Application Reference Number:	2025/0498.
--------------------------------------	------------

Proposal Description:	<i>Formation of vehicular access and dropped kerb.</i>
Location:	<i>8 Welfare View, Barnsley Road, Dodworth, Barnsley, S75 3LB.</i>

**Vehicle Tracking**

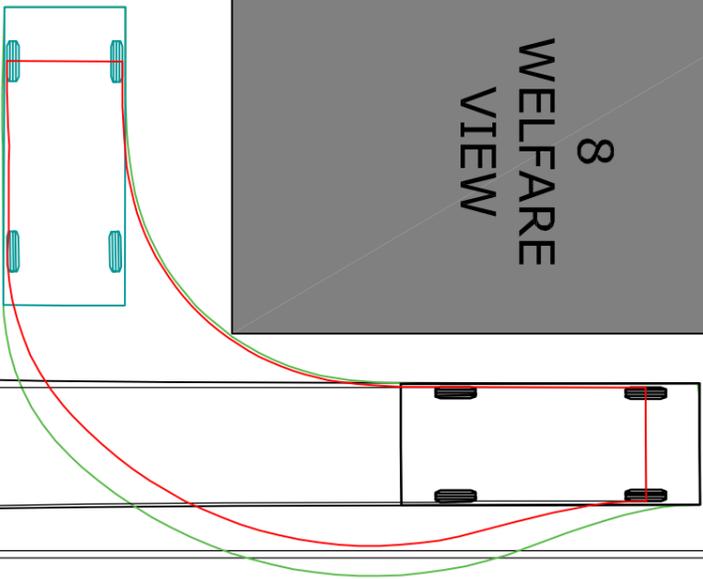
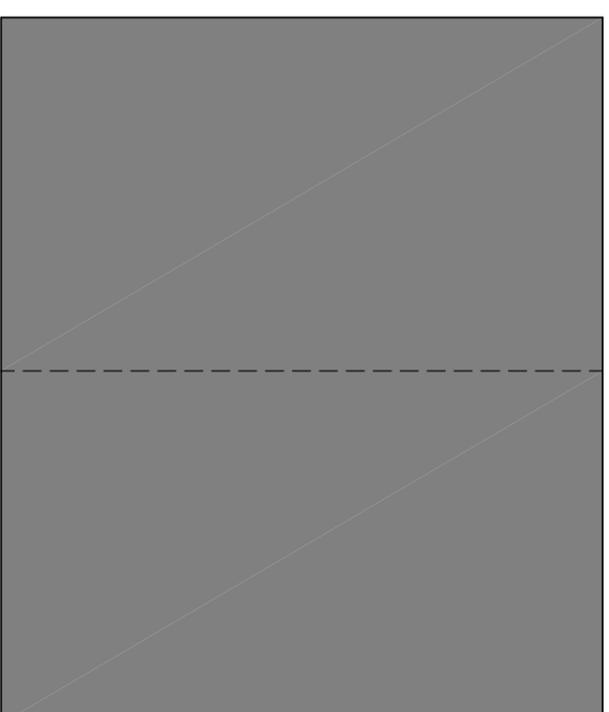
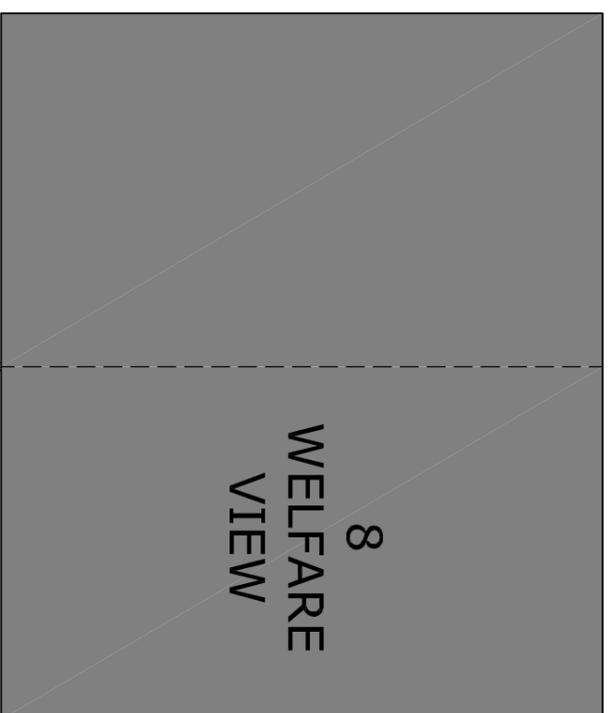
During the application process, concerns were raised regarding the potential for reversing of vehicles onto a busy main road which could cause conflict with other road users, and a lack of turning space within the site to allow access and egress in a forward gear to avoid unsafe manoeuvres and possible conflict. The applicant initially provided videos and vehicular tracking to support the initial proposed scheme. However, this demonstrated that the development site could not achieve sufficient turning to the front and consequently, the applicant submitted an amended scheme.

The amended scheme includes the removal of part of an existing front stone boundary wall and the installation of a dropped kerb and vehicular access off Welfare View. A new driveway would extend the full length to the east within the development site and an existing gated access to the rear would be retained and utilised. The amended scheme would provide entry off Welfare View with exit taken from a rear access road and onto Thornley Avenue (or vice versa). While the proposed arrangement would be unusual, Highways Development Control have raised no objections as it is acknowledged that the proposal is a workable scheme in theory, particularly given local context with neighbouring properties having a range of different off-street parking facilities.
